Application no: **3/2019/0328**

Address: **Black Hall Cottage Garstang Road Chipping PR3 2QJ**

Proposal: **Exercise area for horses**

Site Plan.

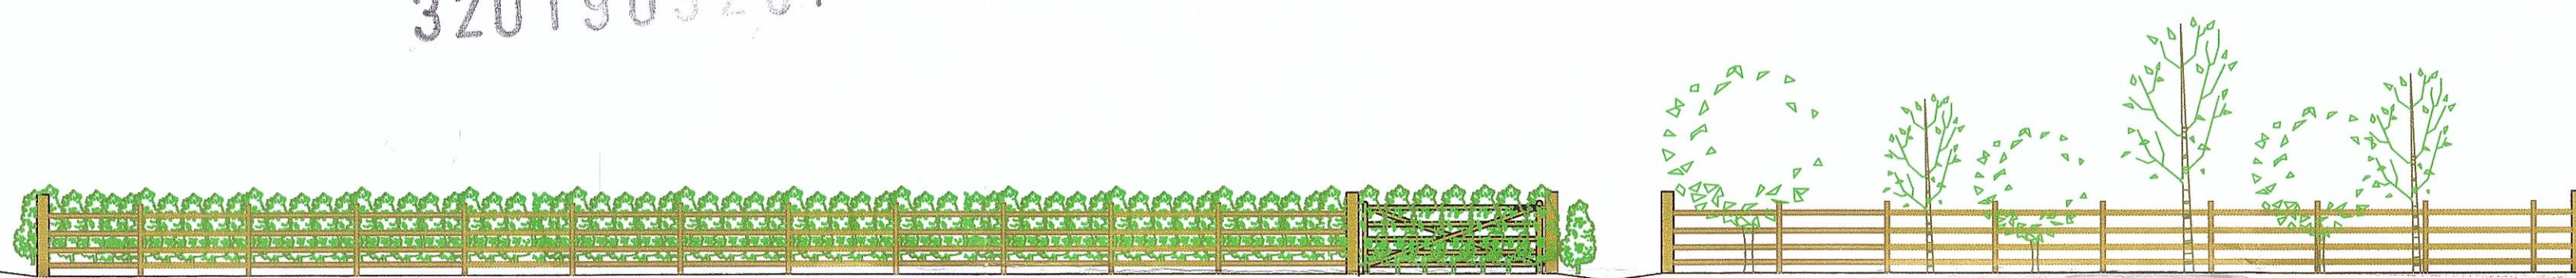
Access to the proposed development will be via an existing access point onto Garstang Road.

Garstang Road is a classified Road namely C566 which is also subject to the national speed limit.

1. Before the access is used for vehicular purposes, that part of the access extending from the highway boundary for a minimum distance of 5m into the site shall be appropriately paved in tarmacadam, concrete, block pavements, or other approved materials. **Reason:** To prevent loose surface material from being carried on to the public highway thus causing a potential source of danger to other road users.
